Response to Planning Application

From: Arun District Council Greenspace

Application ref: P/153/21/RES

Location: Land South of Summer Lane and West of Pagham Road Pagham

LEAP (Local Equipped Area of Play) - Design Approach

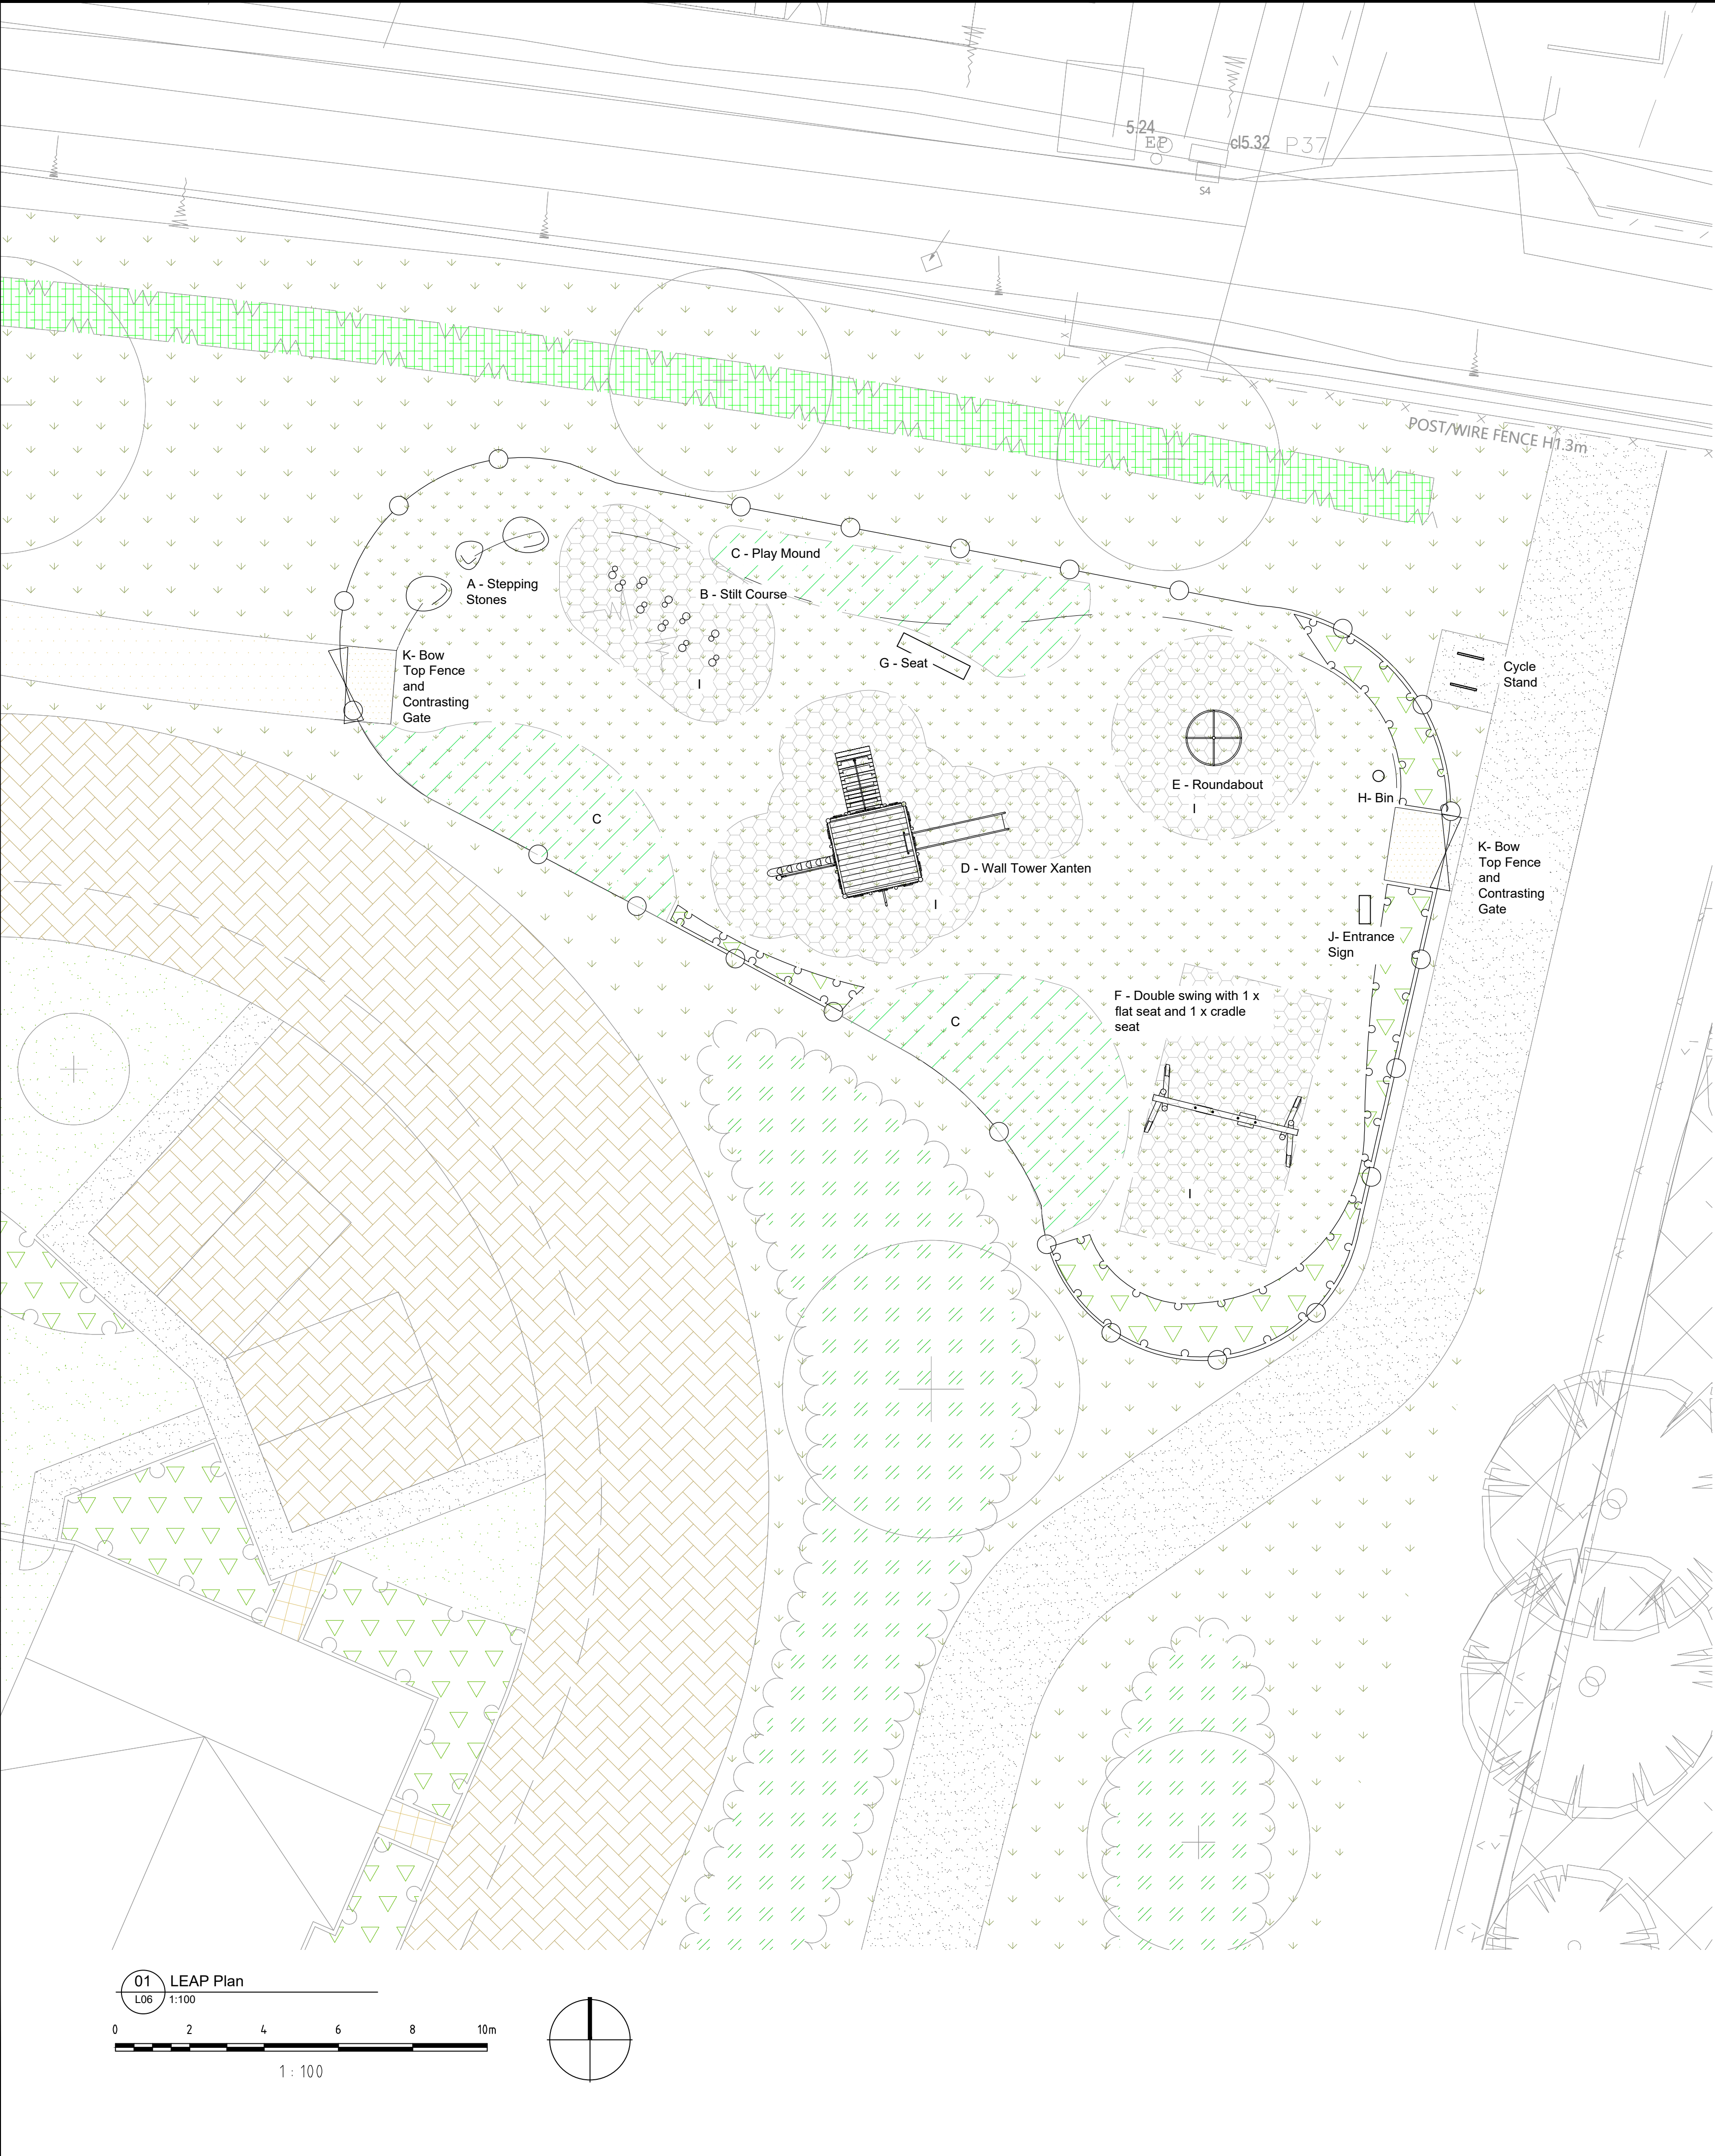
The LEAP Northern Parcel DD494L06 Rev B design appears inadequate in inclusive an accessible play in line with the Arun Design Guide Jan 2021. The equipment appears limited in play experience offered. Swings shown as two flat seats, which are less accessible and exclude the use by very young children (ie the introduction of basket swings cater to a wider audience). The play detail fails to demonstrate what is proposed re pathway connection and surfacing to POS areas shown as self-binding gravel would not be recommended due to maintenance issues in high traffic areas for particularly all-weather accessibility and wheeled users. The indicated grass play mounds have no contour or height detail or detail of how these then interface with the adjacent fencing.
